Subject: Response To Application Number AL/107/18/PL at Nyton Stables, Nyton Road, Aldingbourne, Chichester, PO20 3TX

WEST SUSSEX COUNTY COUNCIL CONSULTATION

TO:	Arun District Council FAO:Simon Davis
FROM:	WSCC - Highways Authority
DATE:	5 March 2019
LOCATION:	Nyton Stables, Nyton Road, Aldingbourne, Chichester, PO20 3TX
SUBJECT:	AL/107/18/PL Application for continued use for 3 No. approved permanent showpersons plots (temporary permission granted under AL/119/10/ & permanent permission granted under AL/10/14/PL), planning permission for a further 8 No. plots consistig of 4 No. existing & 4 No. new plots (to a maximum of 11 plots) with associated hard & soft landscaping, boundary treatment, lighting & associated works
DATE OF SITE VISIT:	n/a
RECOMMENDATION:	No Objection
S106 CONTRIBUTION TOTAL:	n/a

Drawing Number: 1032-02
Revision: A
Scale: 1:500@A1

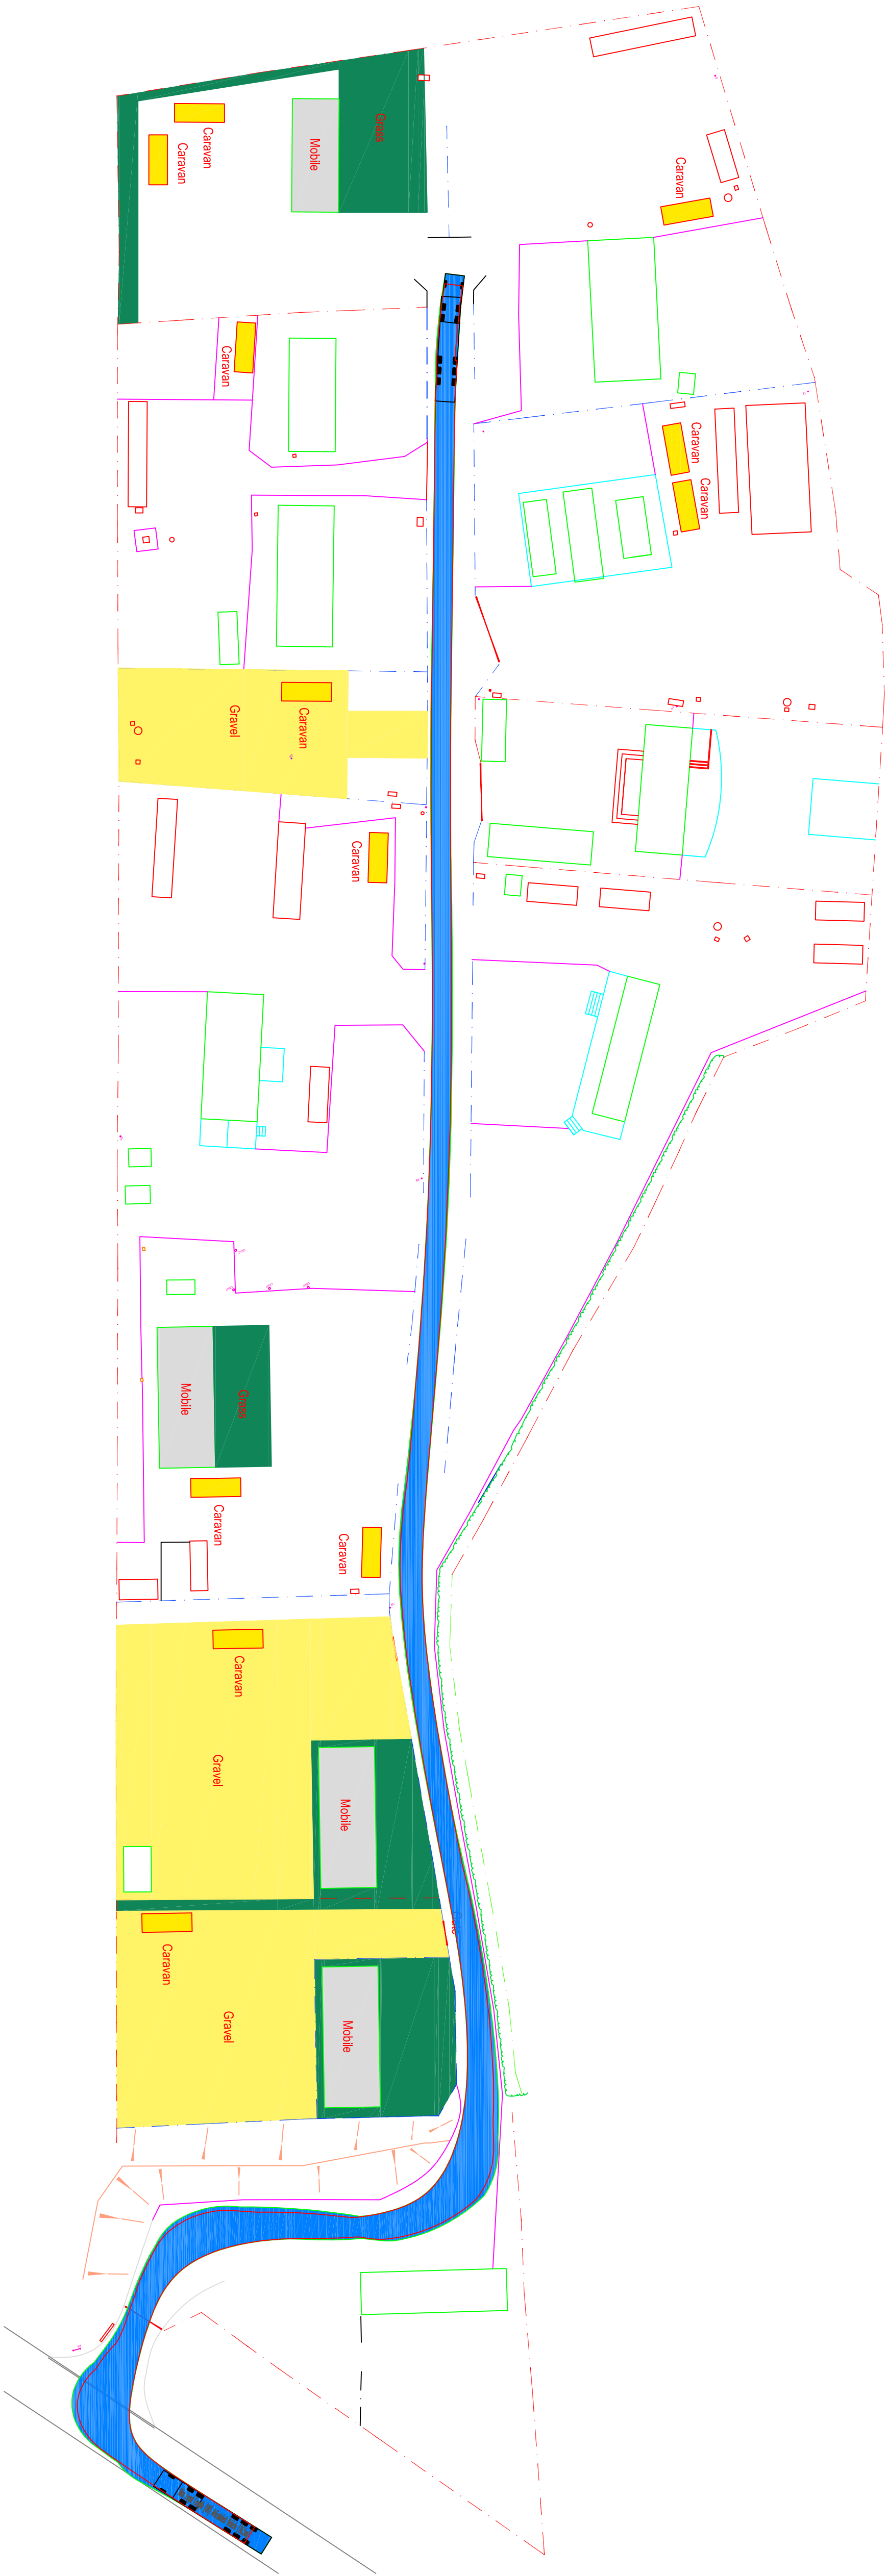
The existing access is wide enough to accomodate the largest vehicle using the site, and as described above will be using the site at specific times of the year when the show people are travelling to fairs for the summer or winter. Swept path diagram 1032-02 Rev A, provides clarity over how a 16.5m articulated lorry can manouvere through the

existing access road from Nyton Lane. There is space at the end of the access road for the parking and turning of HGVS allowing for exit in forward gear.

This will continue as it currently does; however the swept path diagrams confirm a refuse vehicle would be able to enter and exit in forward gear if required.
